Traffic & Safety - Access Permits

SH 094A/Franceville Coal Mine Road
El Paso County

RE: VA256 - Gateway Trucking - Revised Variance of Use

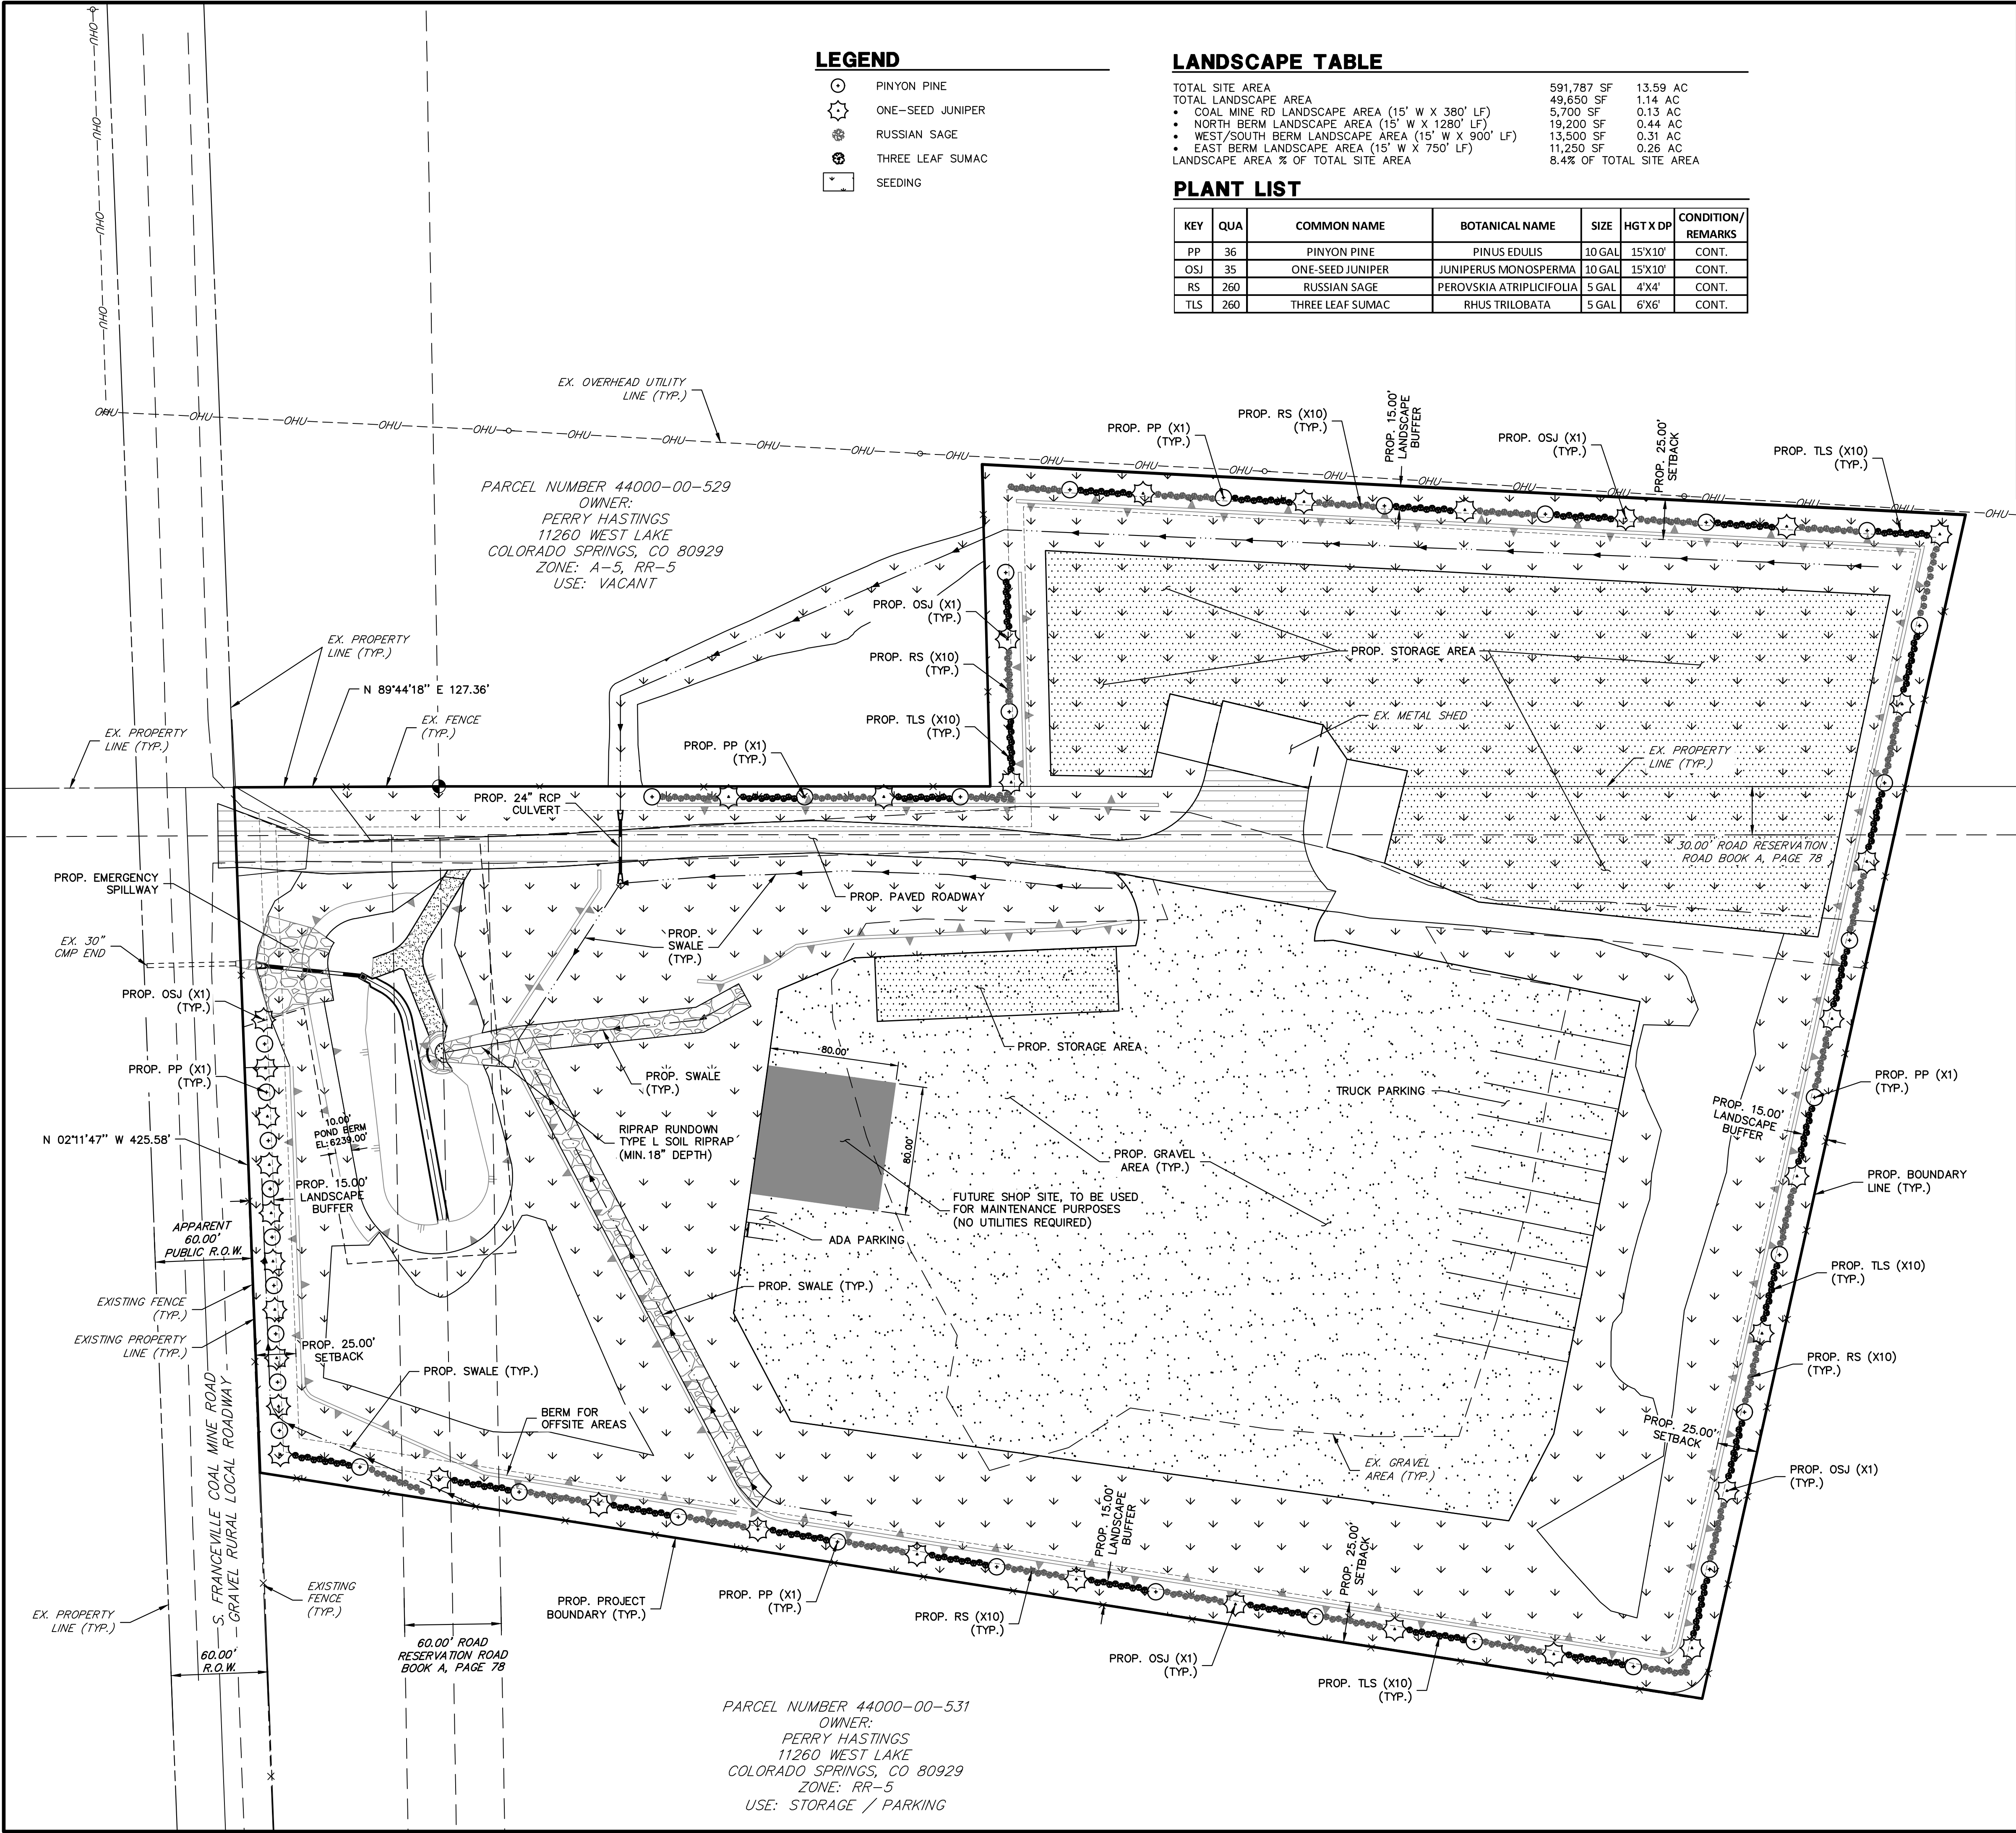
- An eastbound right turn deceleration lane and taper is required on SH94 (500 feet long + 300 feet due overlap of the driveway access to the west + a 300 feet transition taper) with a 4 feet wide paved shoulder and appropriate signage and striping. This may trigger additional application to CDOT Access for the impacts to the access of 12655 SH94.

- A westbound left turn acceleration lane is required as the predicted volume of the traffic in the direction of travel on SH94 exceeds 120 DHV.
- Radiuses of the access are required to be designed and built to allow use by multi-unit trucks without encroachment into other lanes of either roadway.

- Paving of the access (Franceville Coal Mine Road) is required at a width of 36 feet south for a distance of 50 feet at a grade not to exceed 8%.
- The above comments regarding auxiliary lanes, EB right turn decel and NB to WB left turn accel, still apply. The suggested alternatives are not enforceable. The applicant should be aware that full movement access at Franceville Coal Mine Rd and CO 94 may be restricted in the future, should safety concern arise.
